PREFERRED PROJECT REPORT
MP 10_0171

330 CHURCH STREET, PARRAMATTA

JULY 2012

SCALE	PAGE SIZE	STATUS
1:200	A1	PRELIMINARY
DWG DATE MAR 2011	DRAWN BY JF	APPRO BY TC
PLOT DATE 18/5/11	REV	ISSUE 5
DRAWING NUMBER	A097

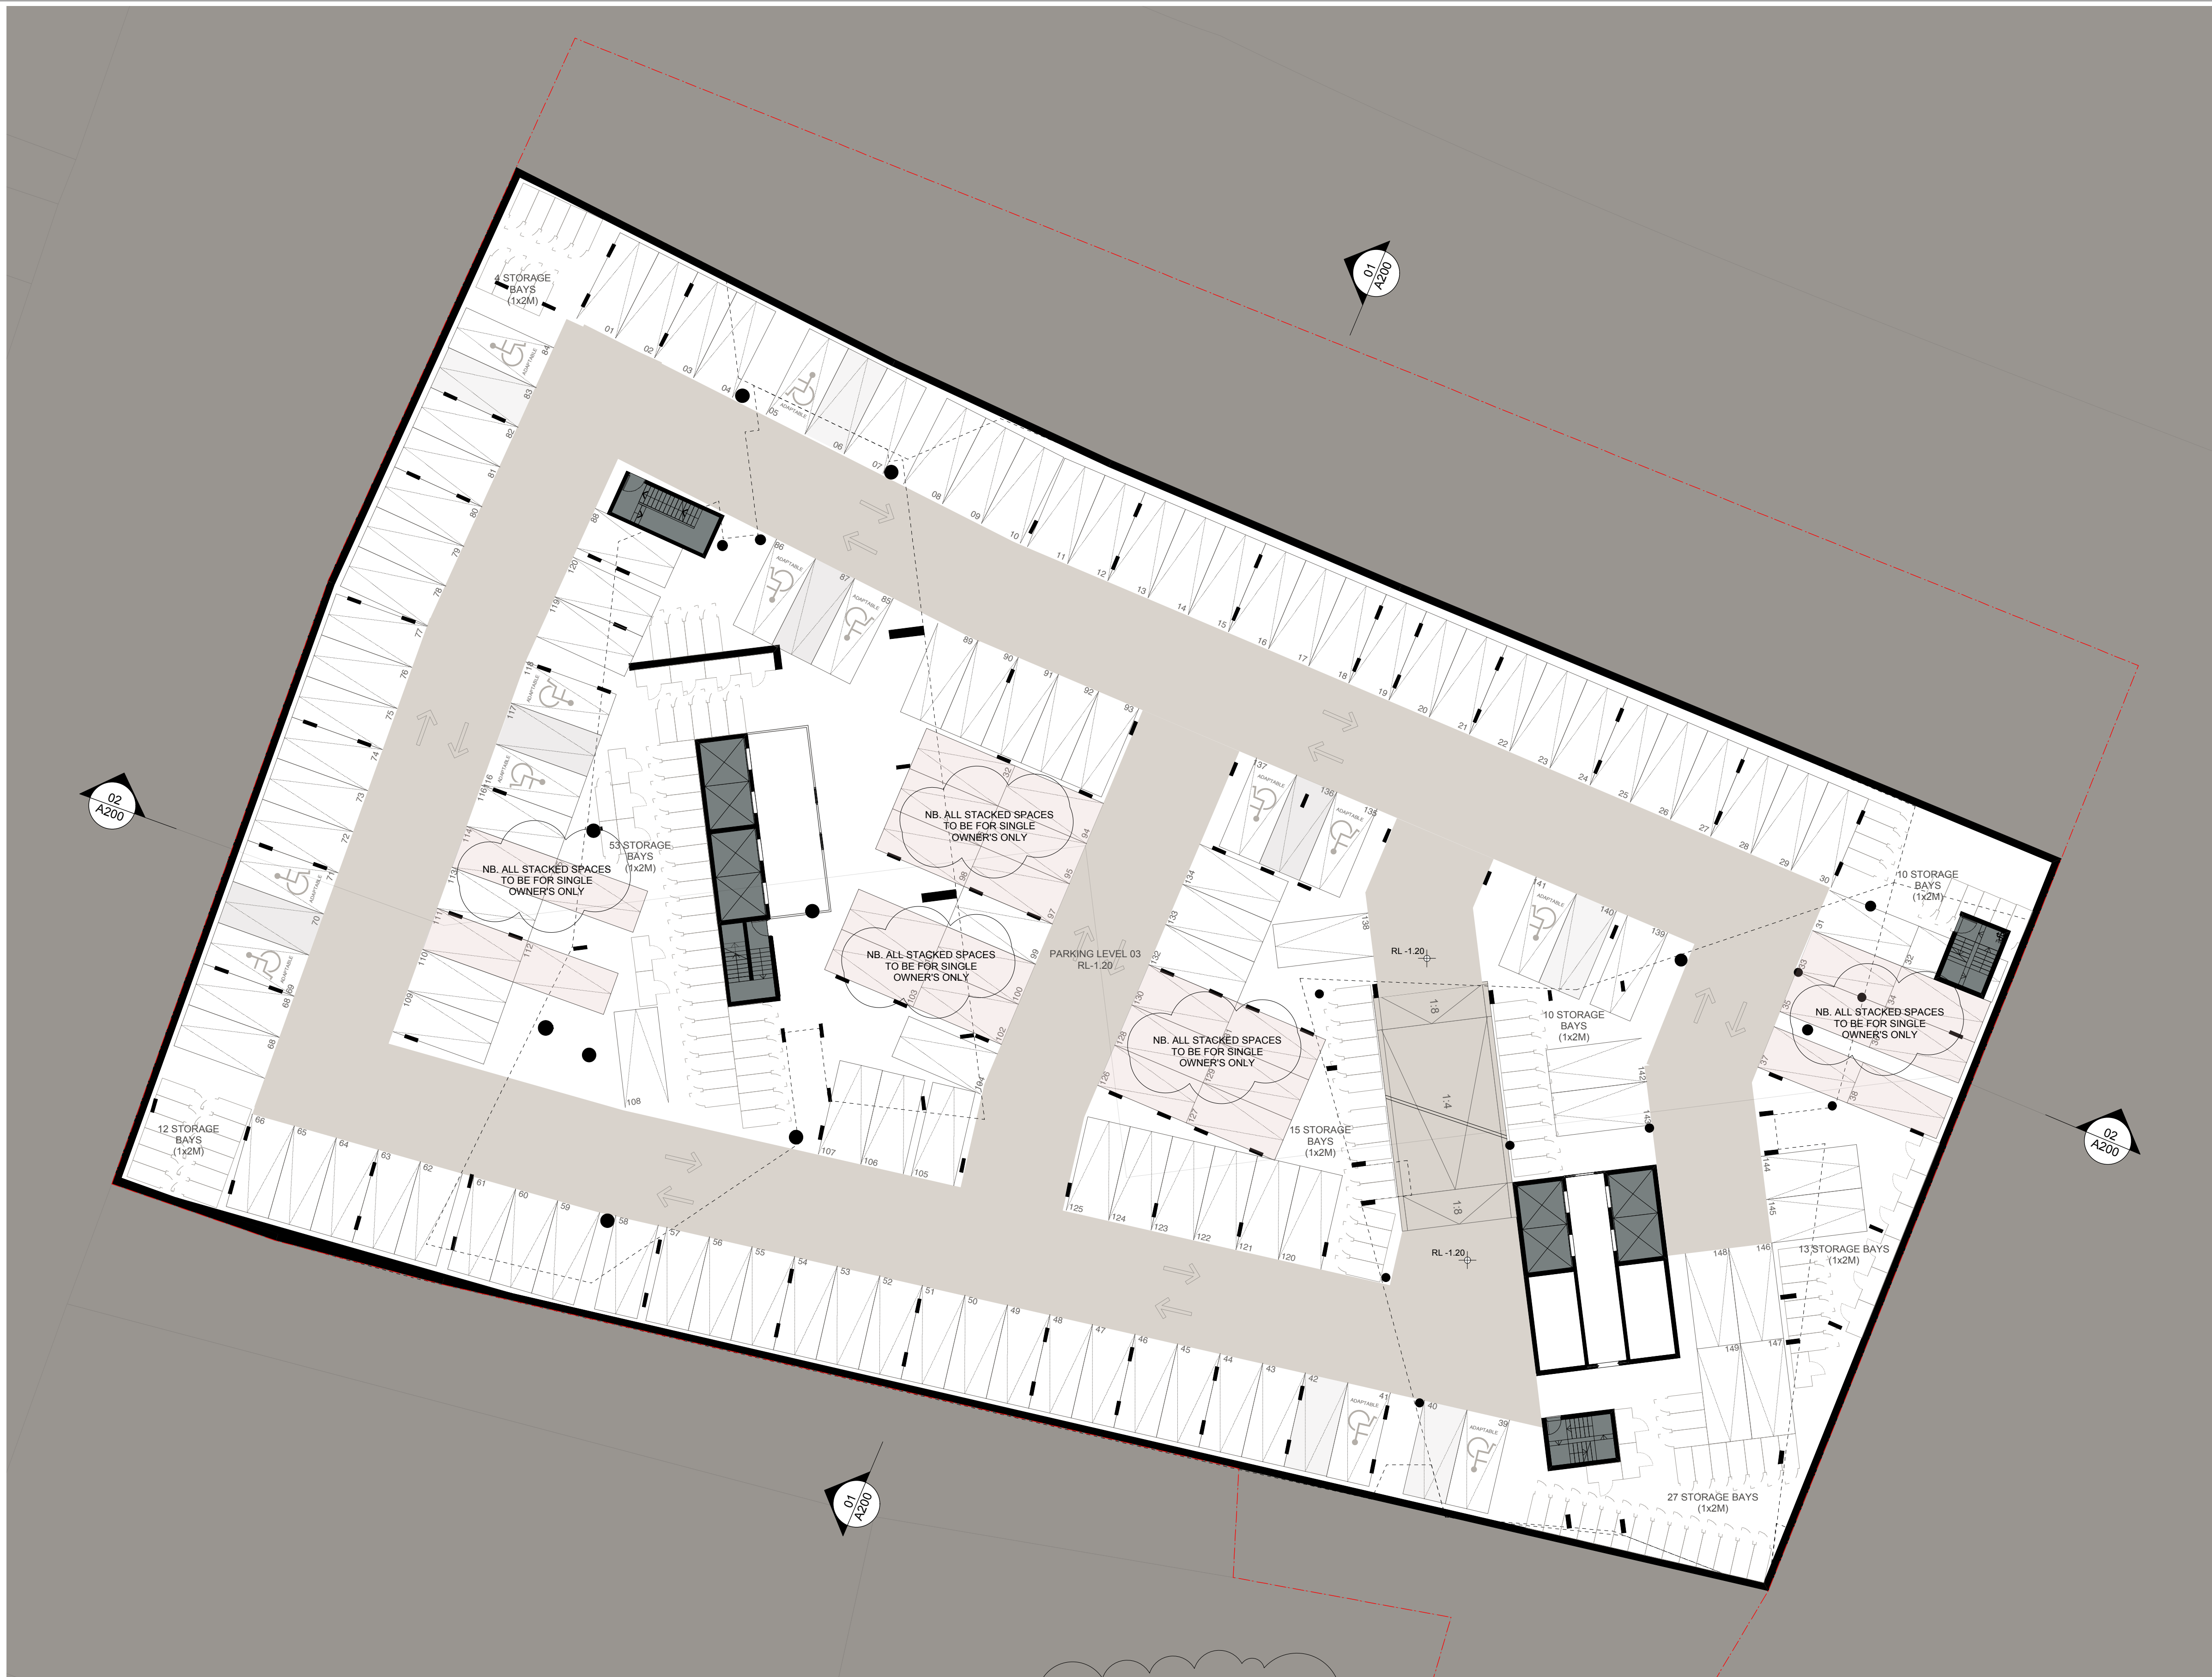
Basement Car Park Plans

The architectural plans have been amended to include bicycle parking in basement plans and schedules. This is now shown on plans A096-A099. The amended architectural plans are at Annexure 3.

SCALE	PAGE SIZE	STATUS
1:200	A1	PRELIMINARY
DWG DATE MAR 2011	DRAWN BY JF	APPR BY TC
PLOT DATE 24/11/11	REV	ISSUE 7
DRAWING NUMBER		A100

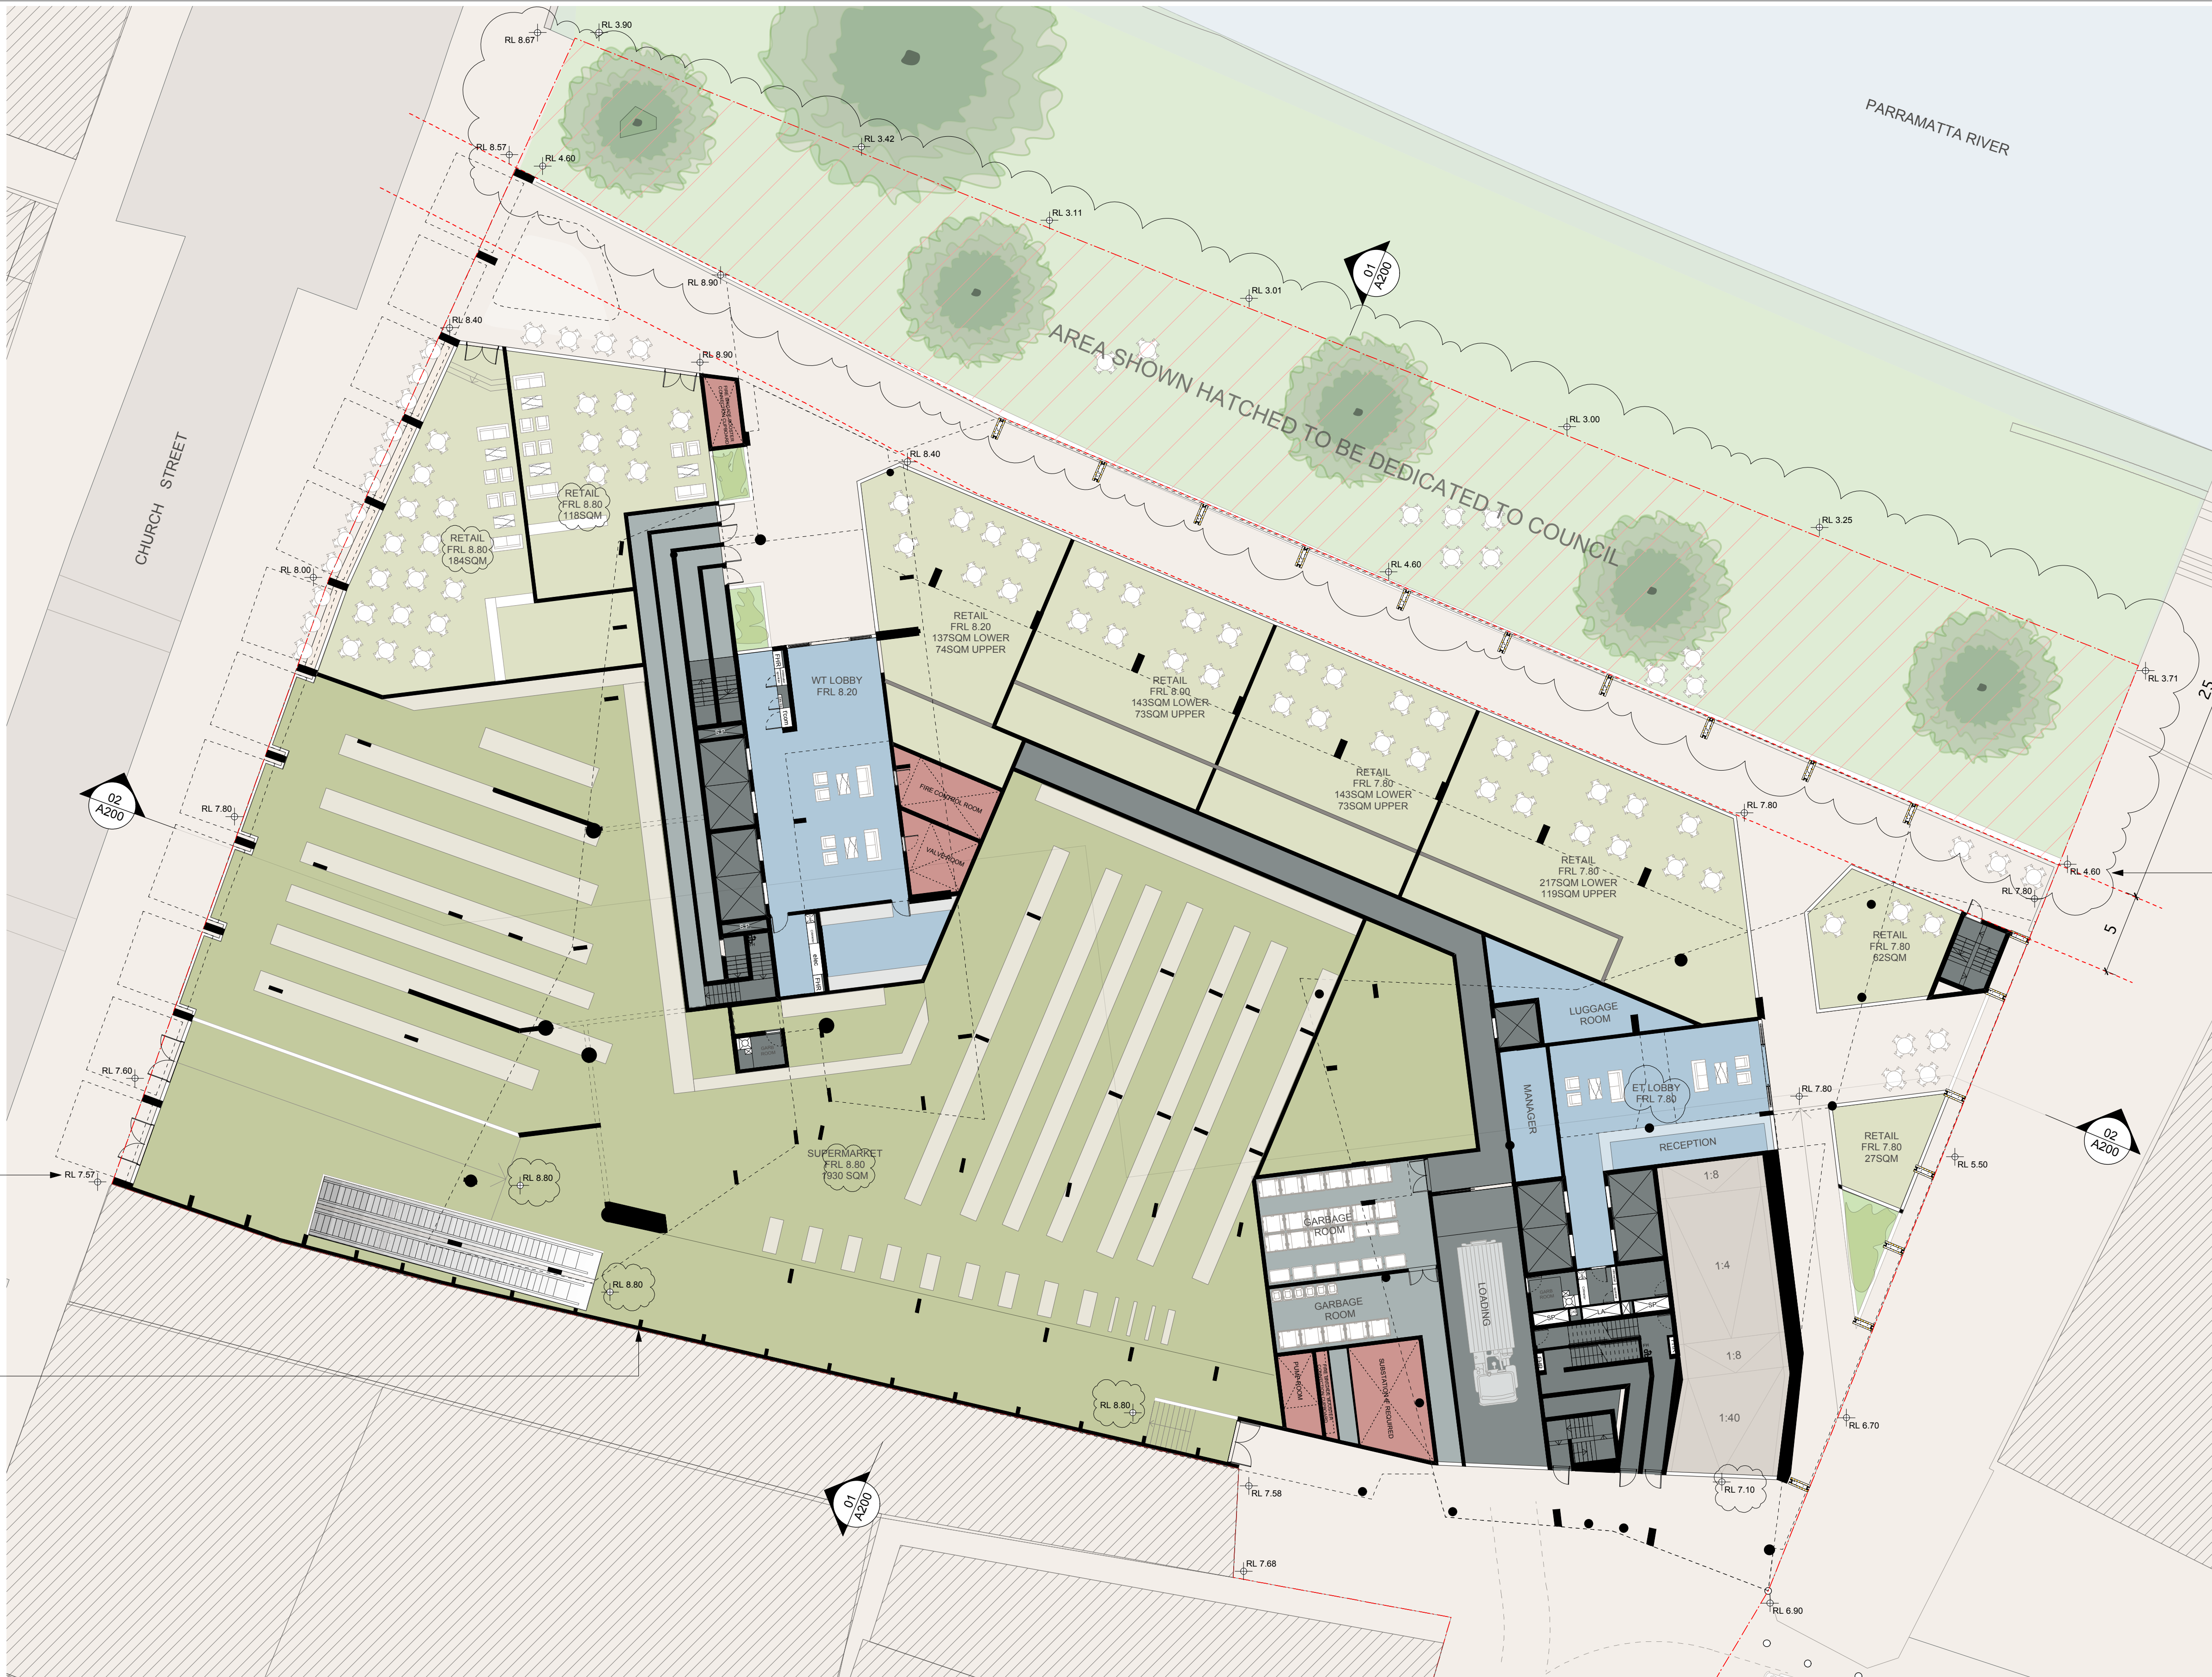
Council's submission identifies some deficiencies in the information provided. The following has been undertaken to address those deficiencies:

The Council has raised concern about how successfully the proposed building interfaces with the existing adjoining development to the south along Church Street.

- The amended architectural plans now show additional RL's on drawing A100;
- Additional dimensions have been added to drawing A100 to reflect the requirements of the Riverside controls;
- The architectural plans have been amended to incorporate proposed materials and finishes. The amended architectural plans are at Annexure 3.

The architectural plans have been amended by lowering the entire Church street facade by 0.8m (see Annexure 3). This is readily achieved as the façade is effectively a free-standing 6m high screen to the Childcare Centre outdoor play space.

The adjoining building to the south is proposed to eventually be demolished once acquired by Parramatta Council. The demolition of the building is to provide for a future laneway. The ability of the proposed development to provide activation of that laneway is shown in drawing A100 (see Annexure 3) - provide an infill glazed façade between framed concrete columns.
